April 14, 2020

Nicole Gaudette, Senior Planner
City of Mercer Island
Community Planning and Development

RE: CAO19-015

PROJECT NARRATIVE - OFFSITE

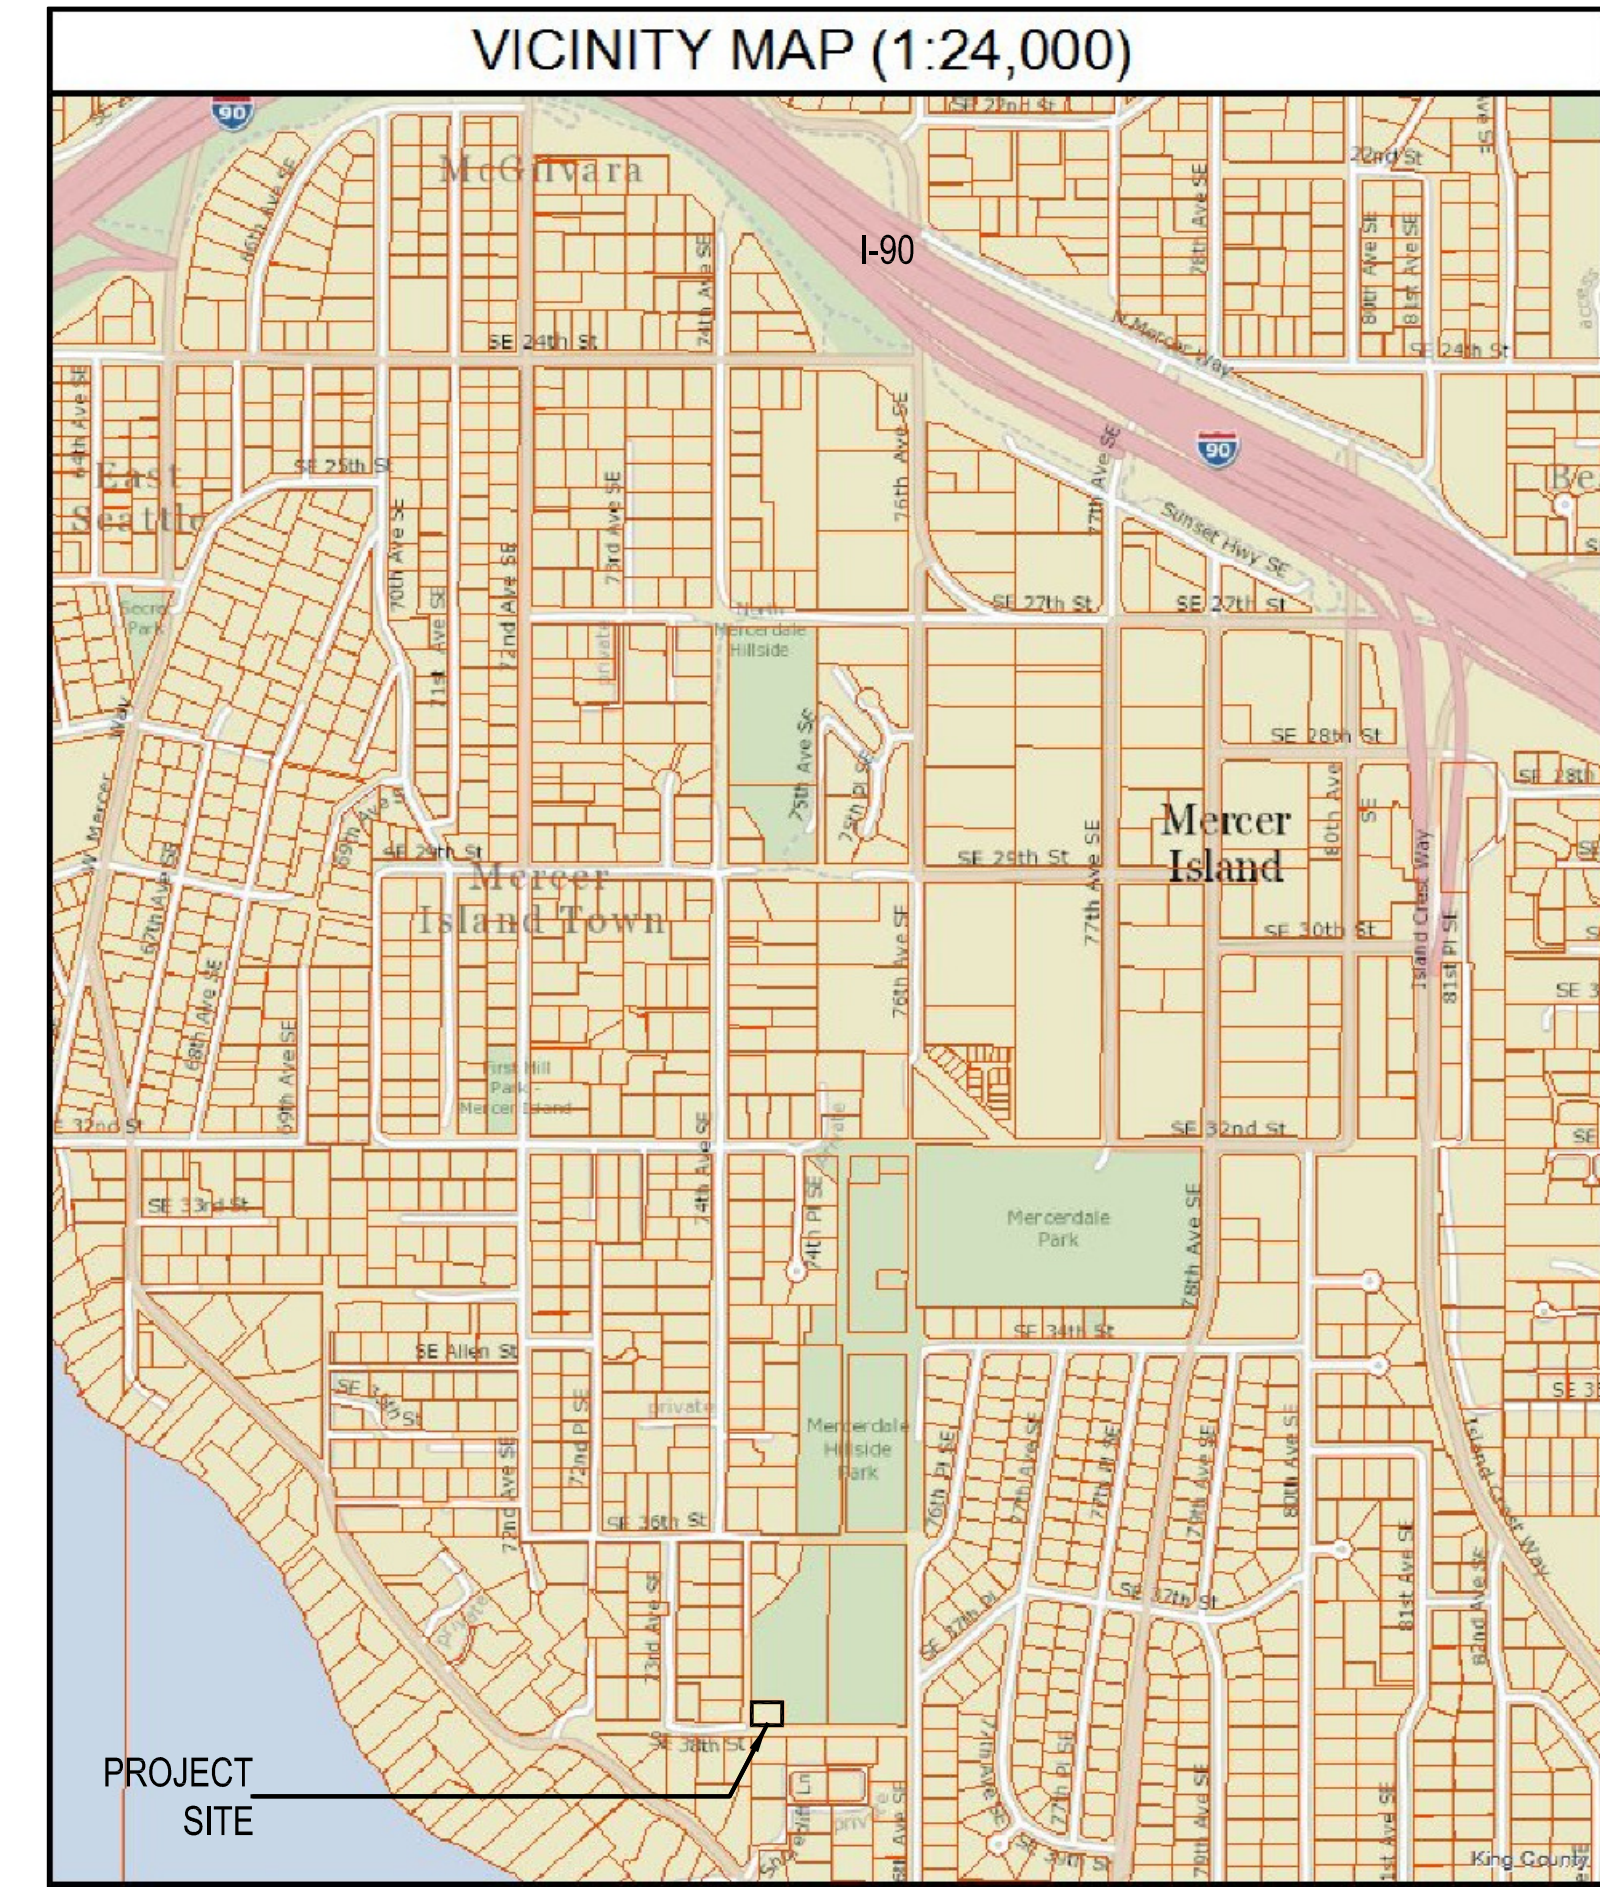
9. Plan Set, Project Narrative – Off Site states in paragraphs 7,8, and 9 that, essentially, natural drainage is to the south, but will be directed to the east. I can’t figure out what this could mean. At the outfall, gravity is going to take the drainage in a natural direction. How can “pointing” it to the east change the direction of flow? Is this allowed? What is impact on neighboring properties?

PAVING AND GRADING PLAN & PROFILE

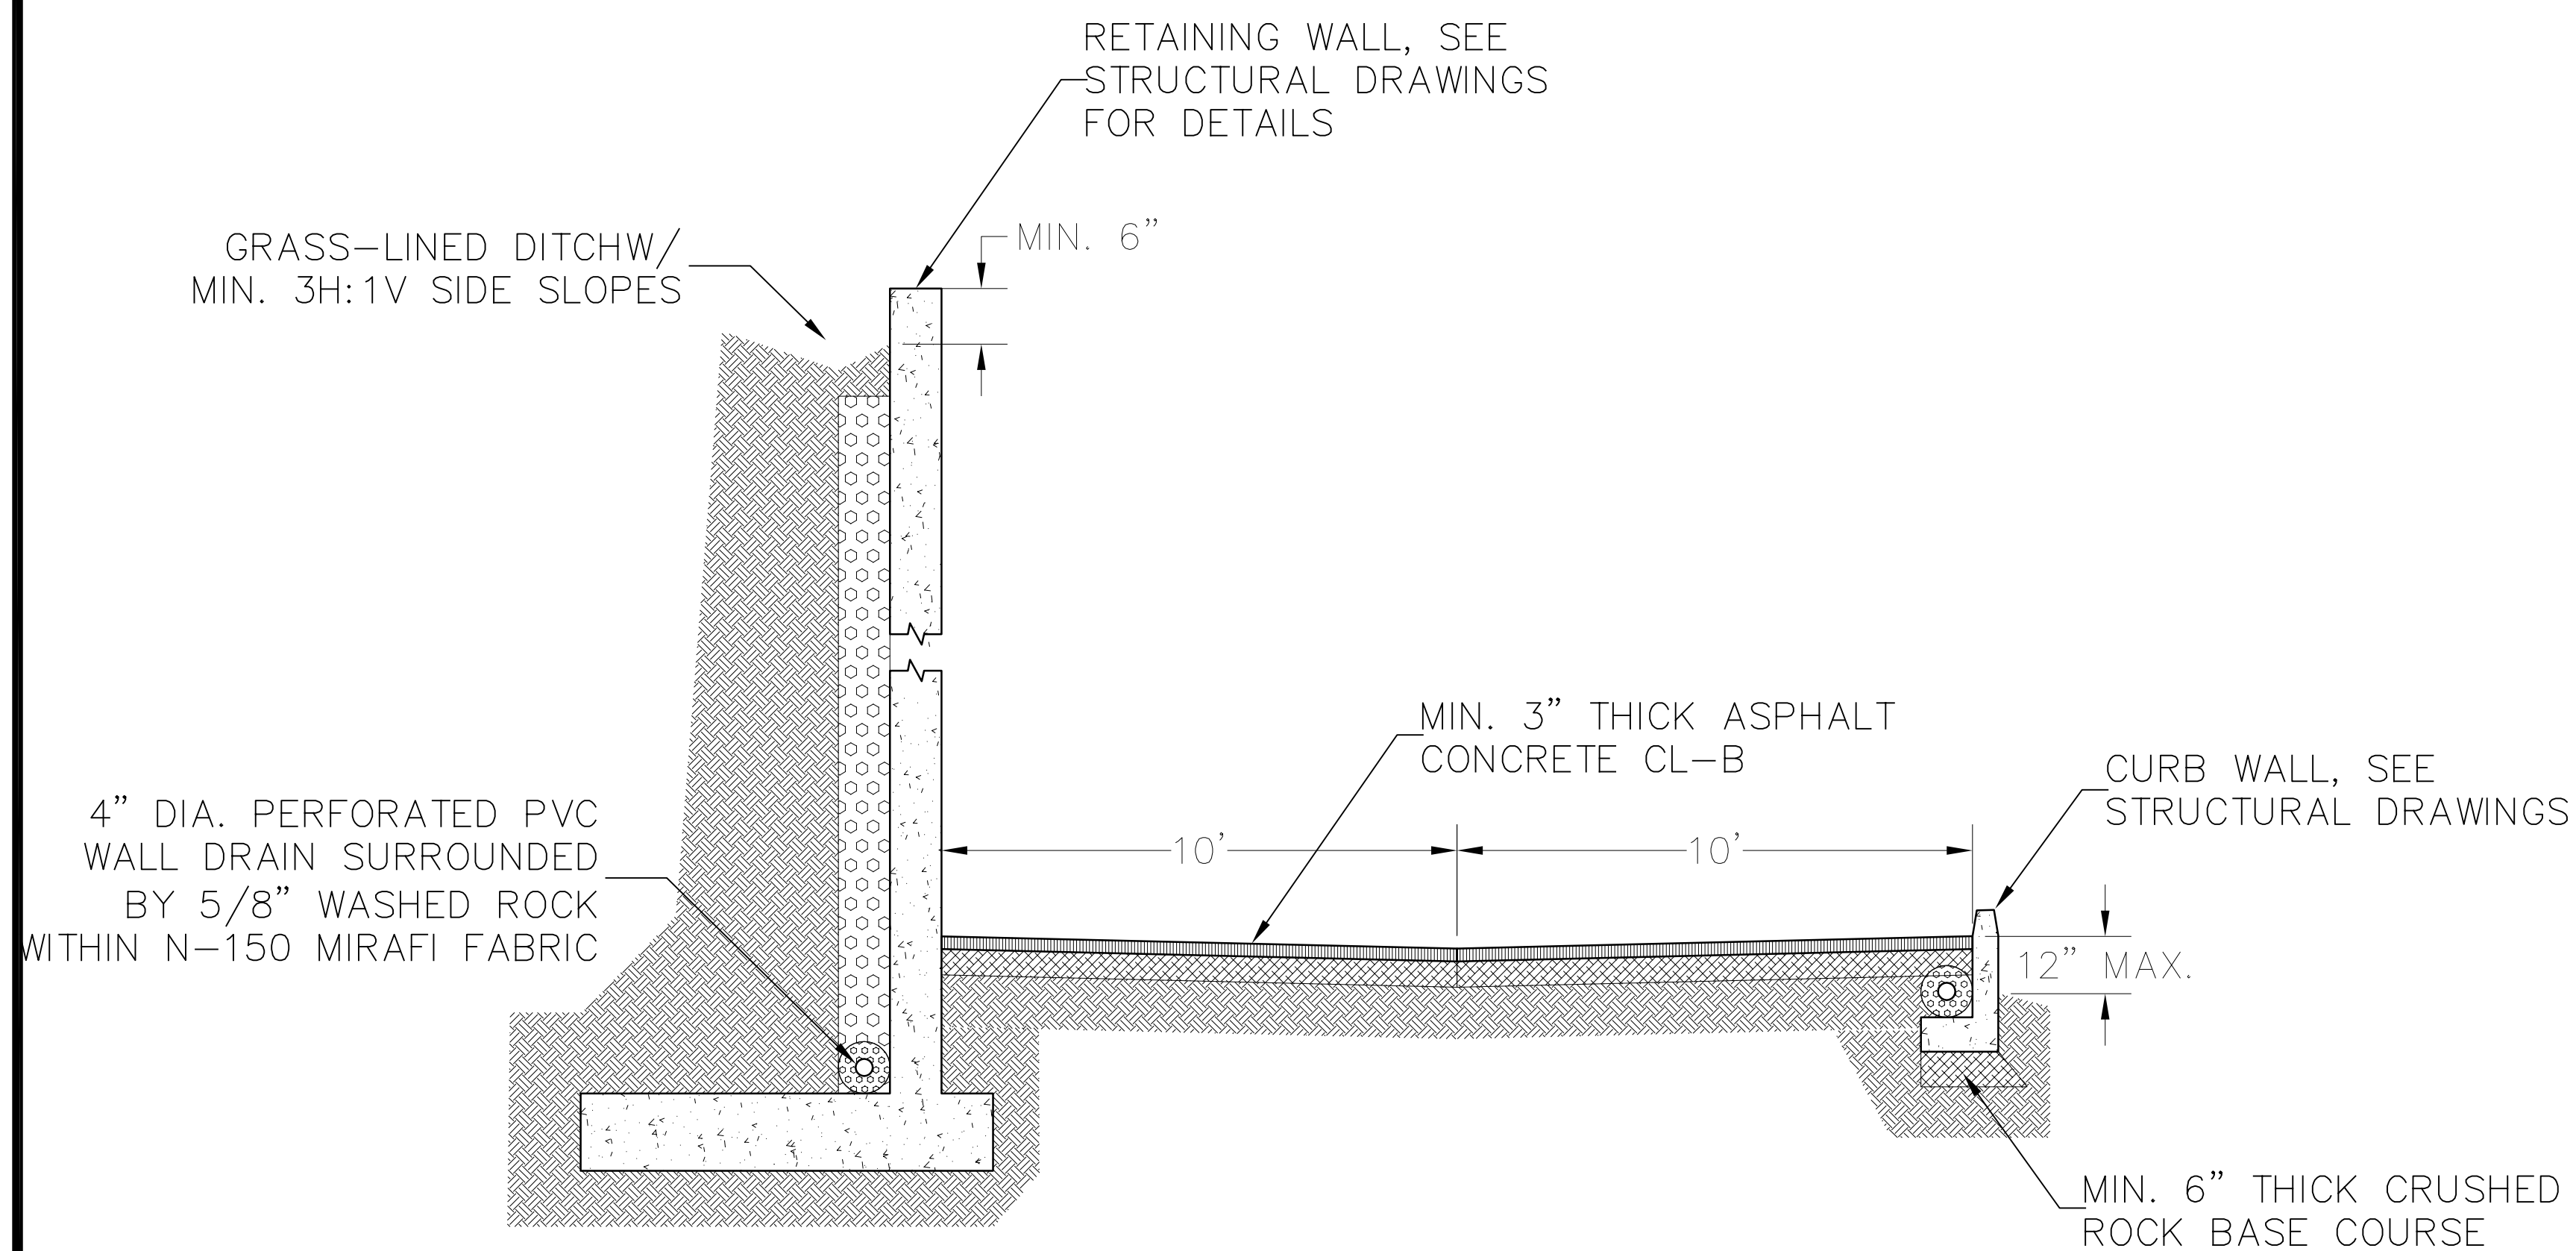
6. The proposed road improvement is distressing. Does the code require the removal of the natural area hillside to the north? Is there code *allowing* the applicant the right or option to take the hillside down? What is driving this rough treatment of a small but delightful native plant natural area in the public right of way, kindly planted and tended by a long-time knowledgeable resident with City permission? Access needs are very limited and the road will never need to be pushed through to 76th AVE SE. What can the City do to minimize the disruption?

7. I see that City code 19.02.020.B. states that residential development fronting on a street must meet City specifications. However, Section 19.09.030.C allows porous pavement in some situations and low impact development in shoulders to manage runoff. Both should be considered carefully. While general soil information, so far, does not encourage low impact development, it could be that a more localized examination of the soil where shoulders are located would tell a different story. Section 19.09.030.E allows for pavement width exceptions in some situations. This should be considered. In short, just like for the preservation of the large tree, City reviewers should get their heads together to try to save this wonderful lane, even though it is a public right of way. It would be most appreciated.

8. I understand the Fire Marshall has stated that a road 20’ to 26’ is necessary for fire access. Would fire protection from the existing hydrant at the bottom of 73rd AVE SE be sufficient?

UTILITIES PLAN & PROFILE

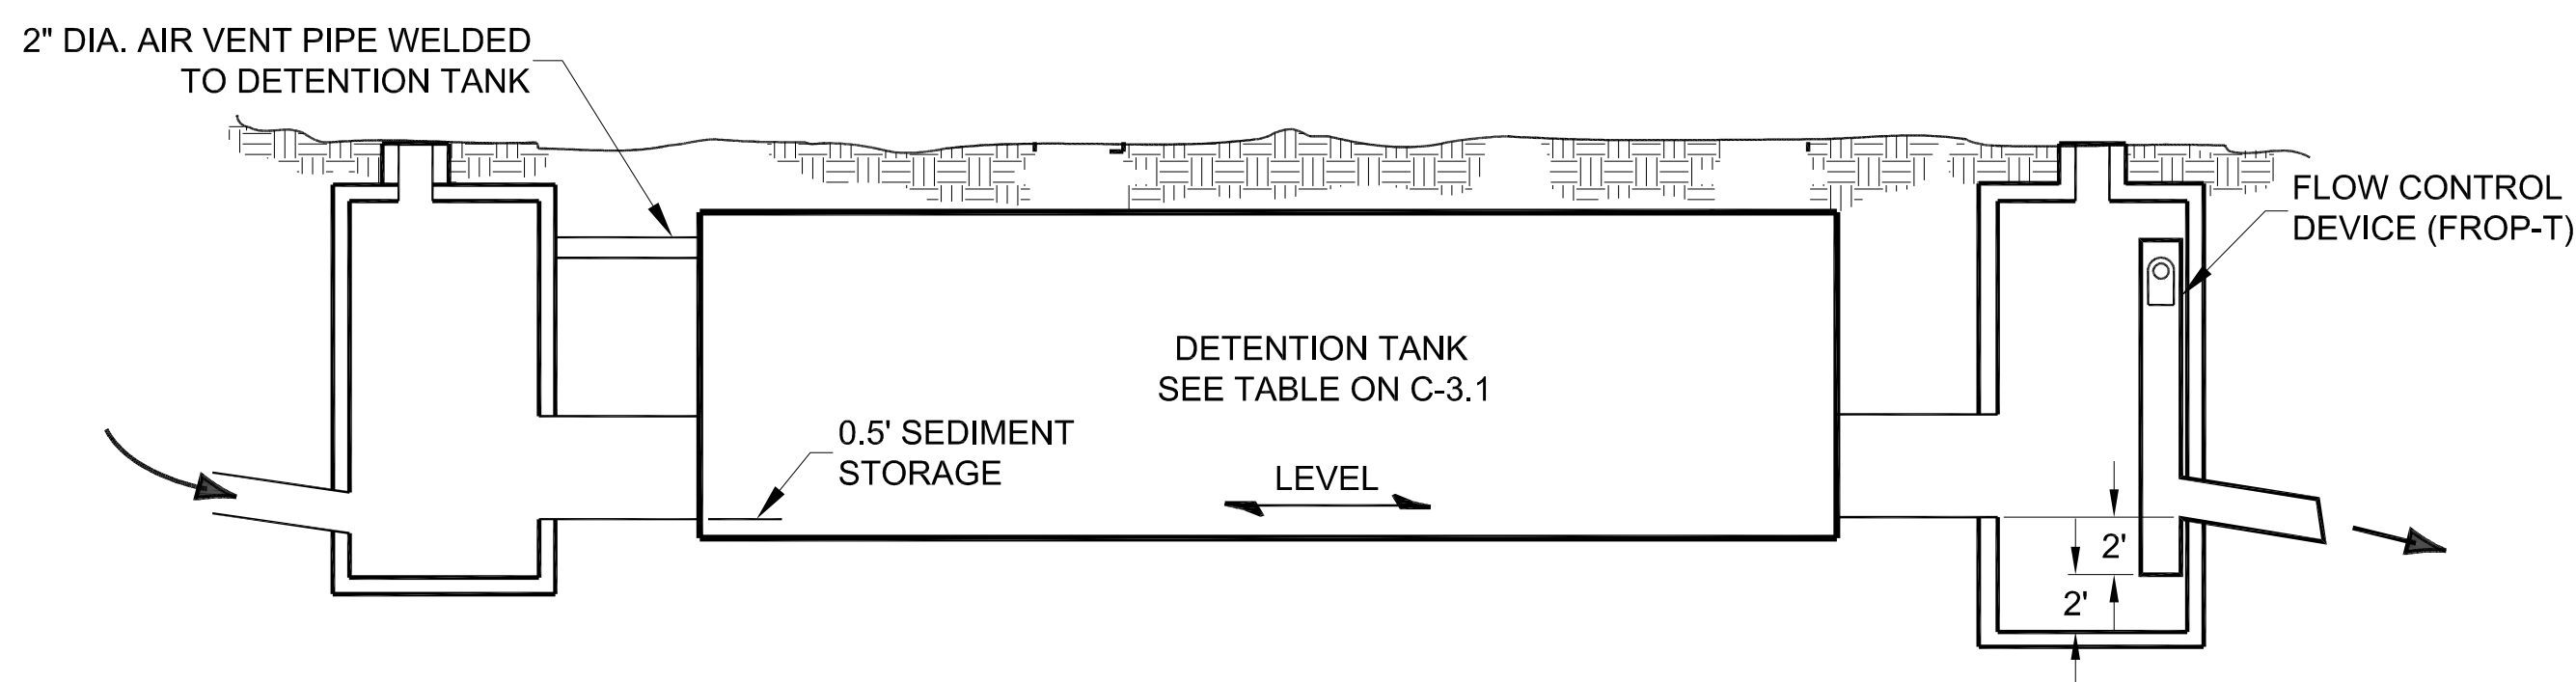
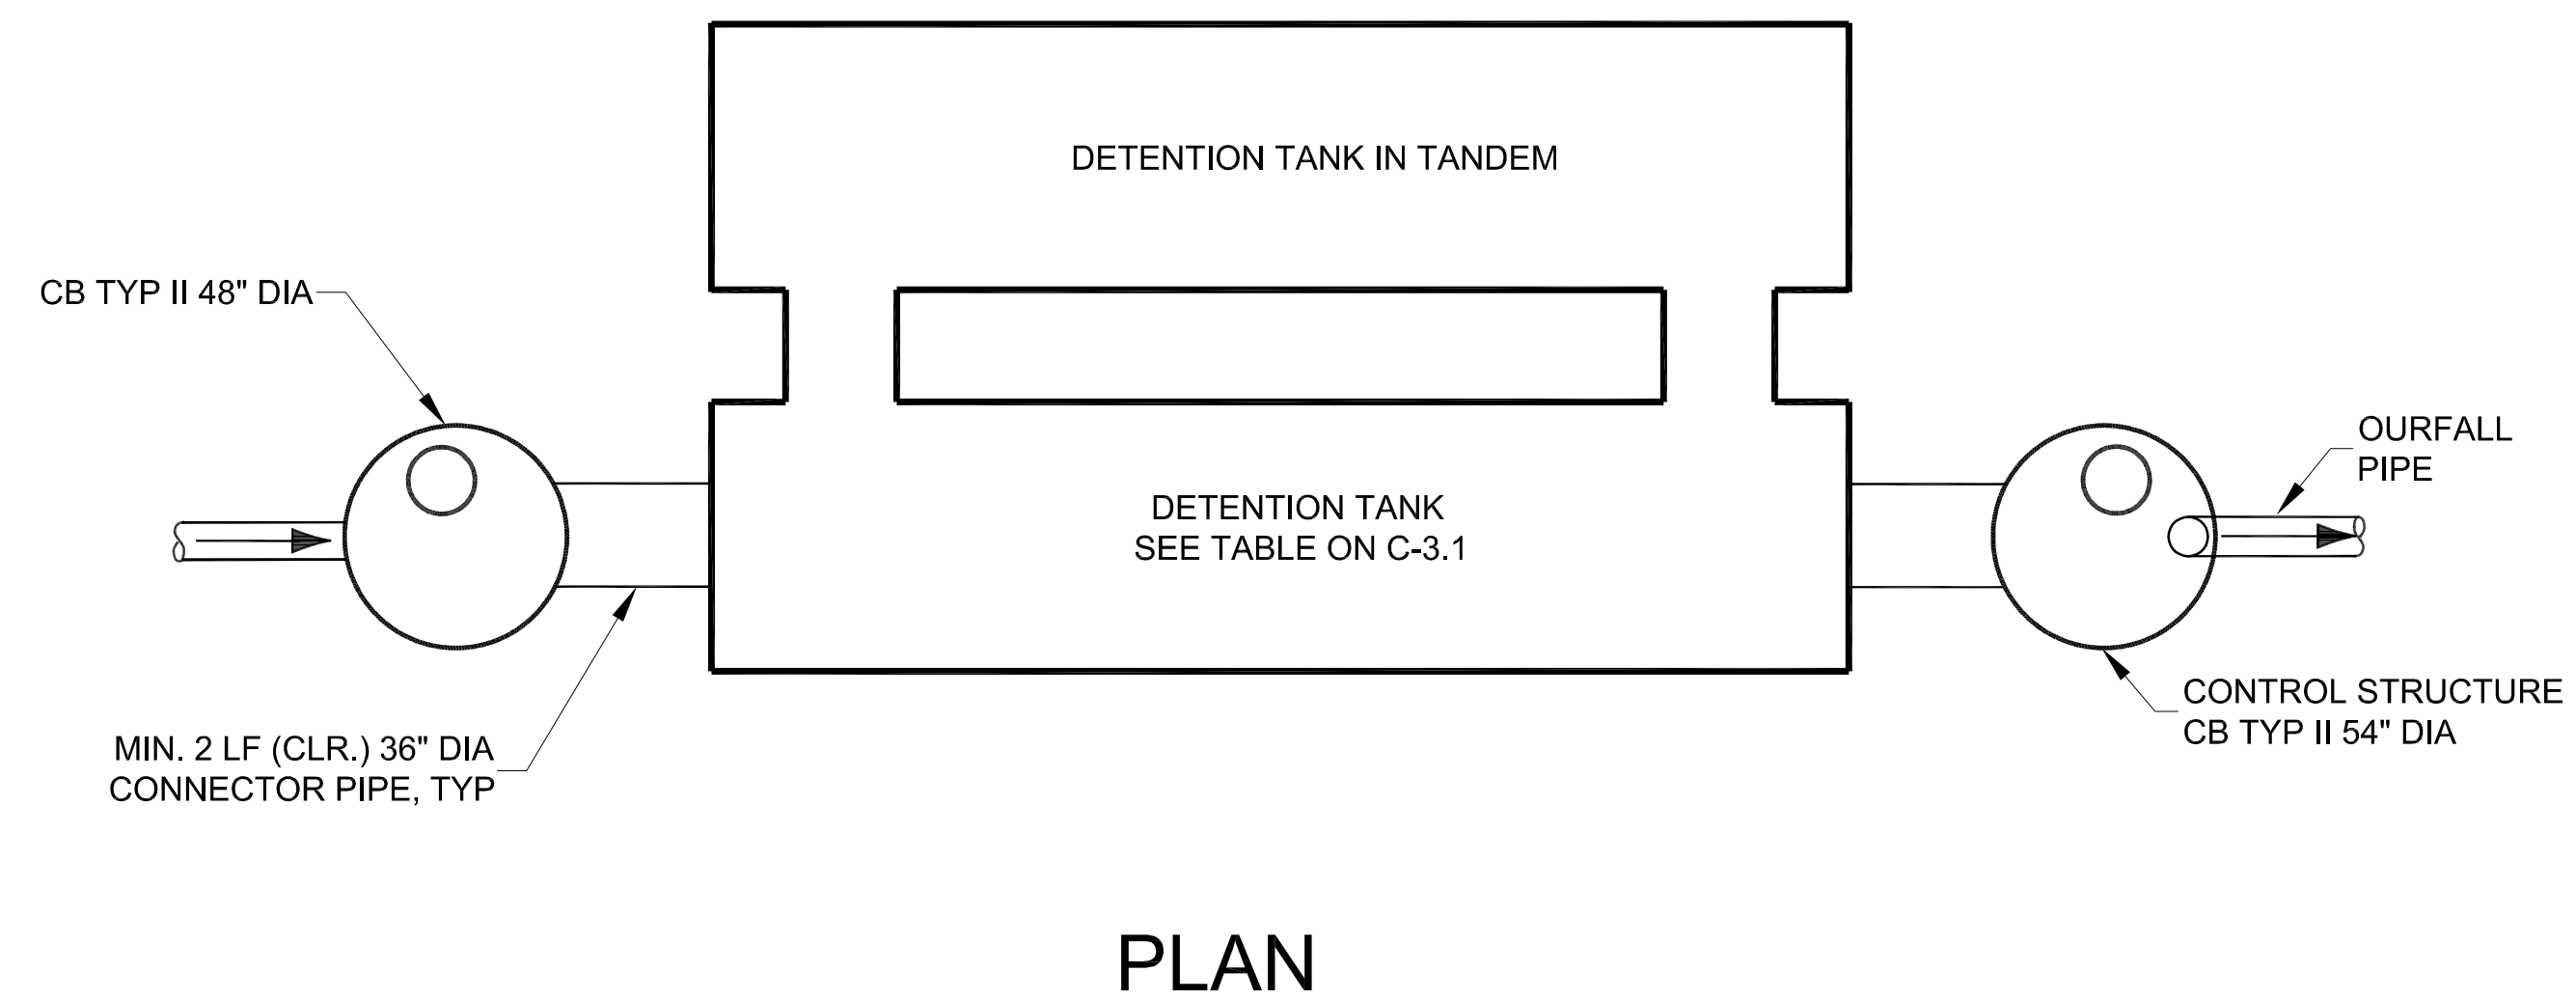
10. The sewer line is installed through the Merceddale open space to reach 76th AVE SE. The pipe will be installed through a wetland. The application does not provide a map of the wetland nor discuss issues associated with installing a sewer line through it. Is a critical area study for the wetland required? The briefest mention of the wetland is in the Wetland Report, 2nd to last sentence.
